**Addendum No. 1**

RE: Contract # C204069

**Wake County (I-5506)**

I-40 and SR-1002 (Aviation Parkway) Interchange

**Design Loading for METAL POLE NO. 6, MAST ARM A**

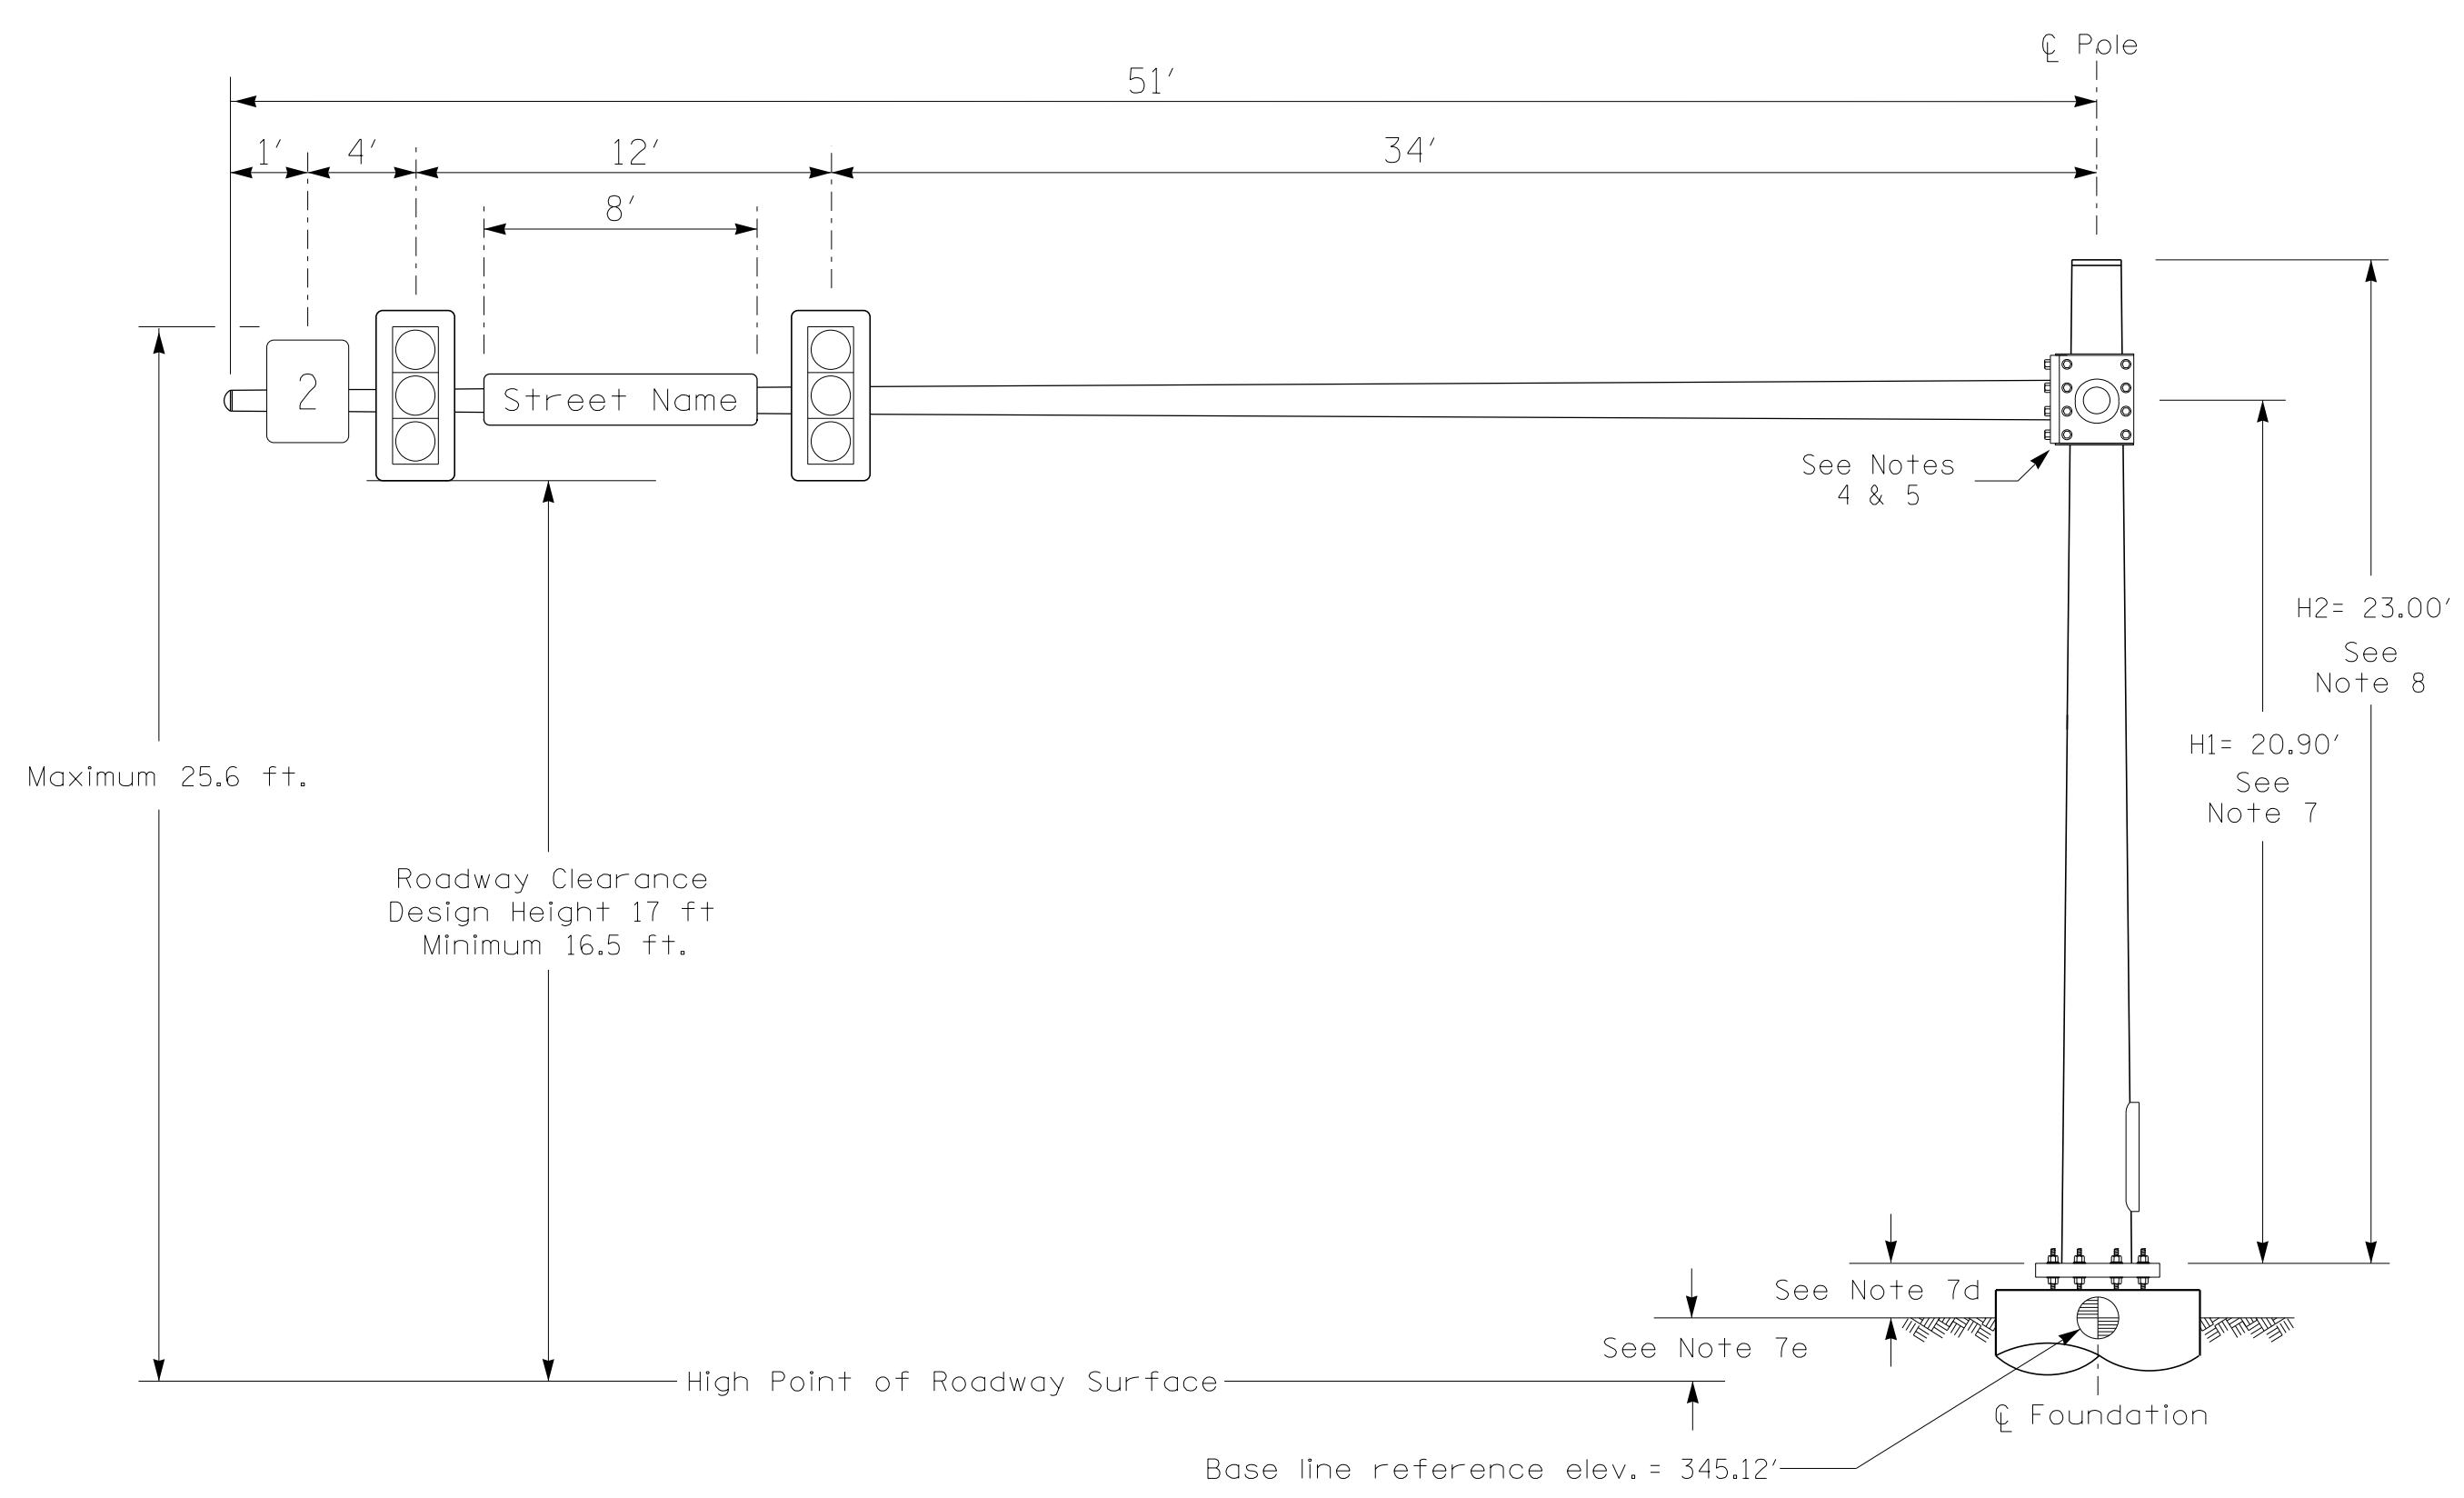
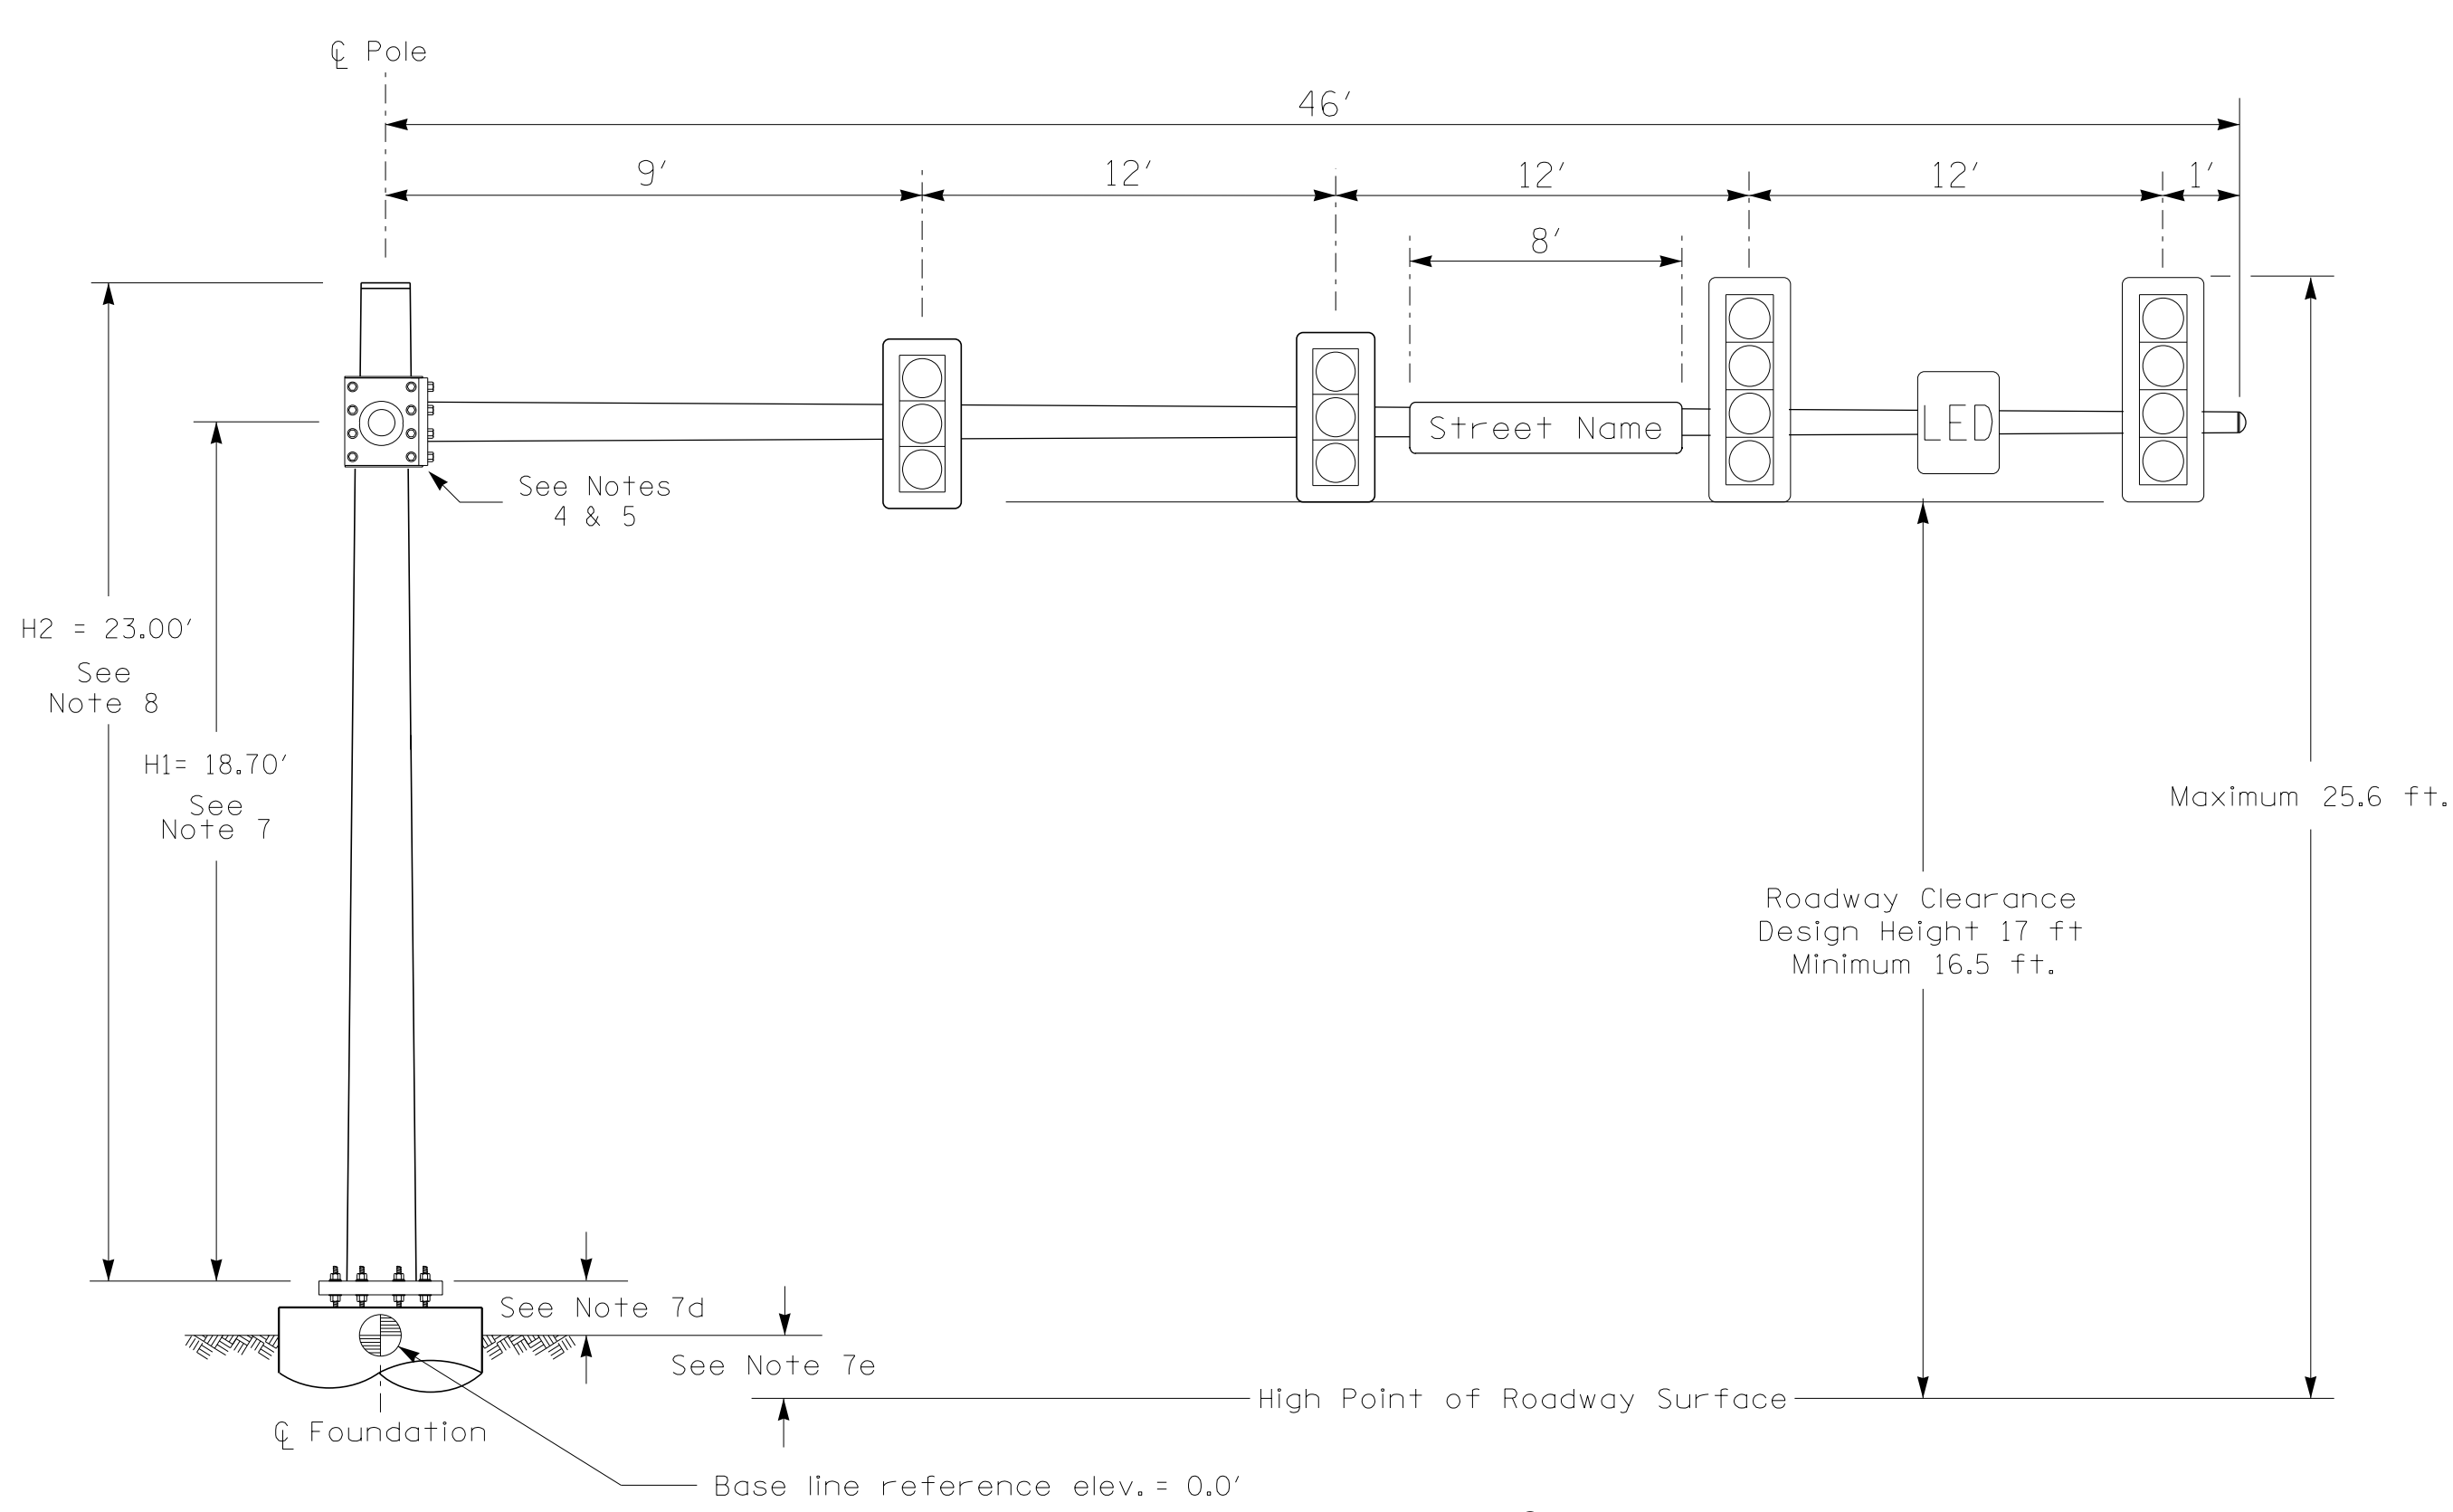
Sheet No.	Revisions
SIGN-1	Revised the Summary of Quantities to reflect the below noted quantity changes
SIG-11.3 and SIG-11.4	New Sheets to provide the loading diagram for "Metal Pole No. 5 and 6"
SIG-16.2 and SIG-16.3	New Sheet to provide the loading diagram for "Metal Pole No. 7 and 8 and Metal Pole No. 9"

Please void sheet No. SIGN-1 in your plans and staple the revised sheet thereto. Please staple new sheet Nos. SIG-11.3 and SIG-11.4 after existing Sheet No. SIG-11.2 and New Sheet Nos. SIG-16.2 and SIG-16.3 after existing Sheet No. SIG-16.1
